Application for non-material amendment following a grant of planning permission

Creation of new private access road.

DM/2020/01320

Retention of part of the existing access road that would otherwise need to be removed per Condition 05 of the Decision Notice along with rationalising the northern part of the proposed new access road to link to the wider side.

DRAWING  
**PROPOSED ACCESS ROAD**

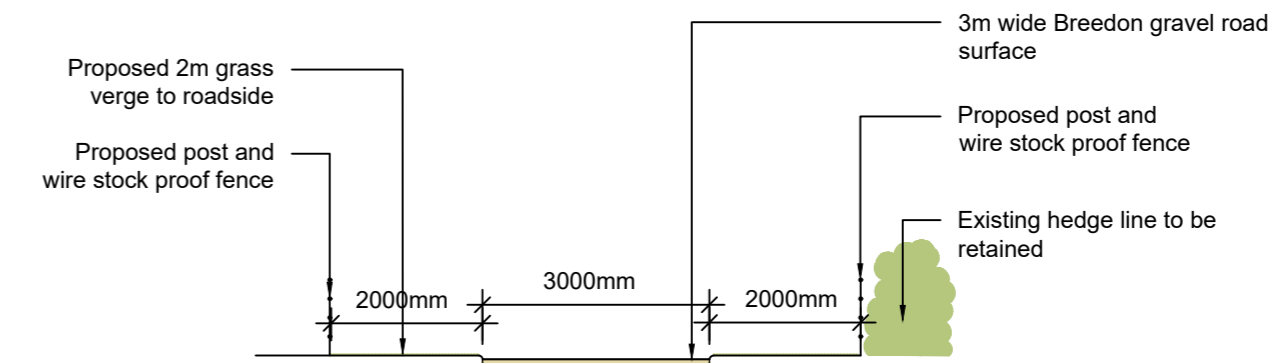
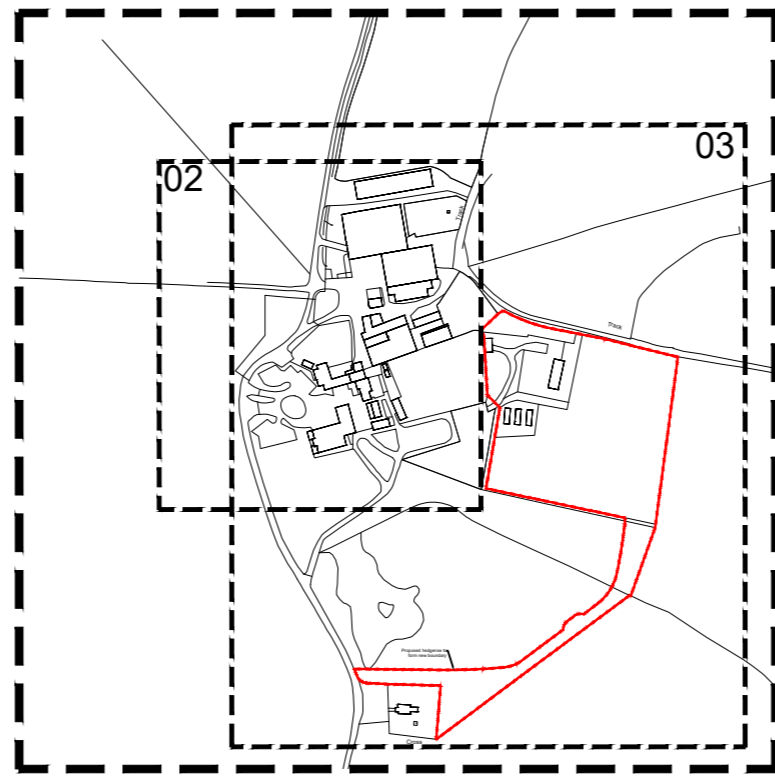
PLN-02 - Existing Access Road Removal REV C
PLN-03 - Proposed Access Road REV C
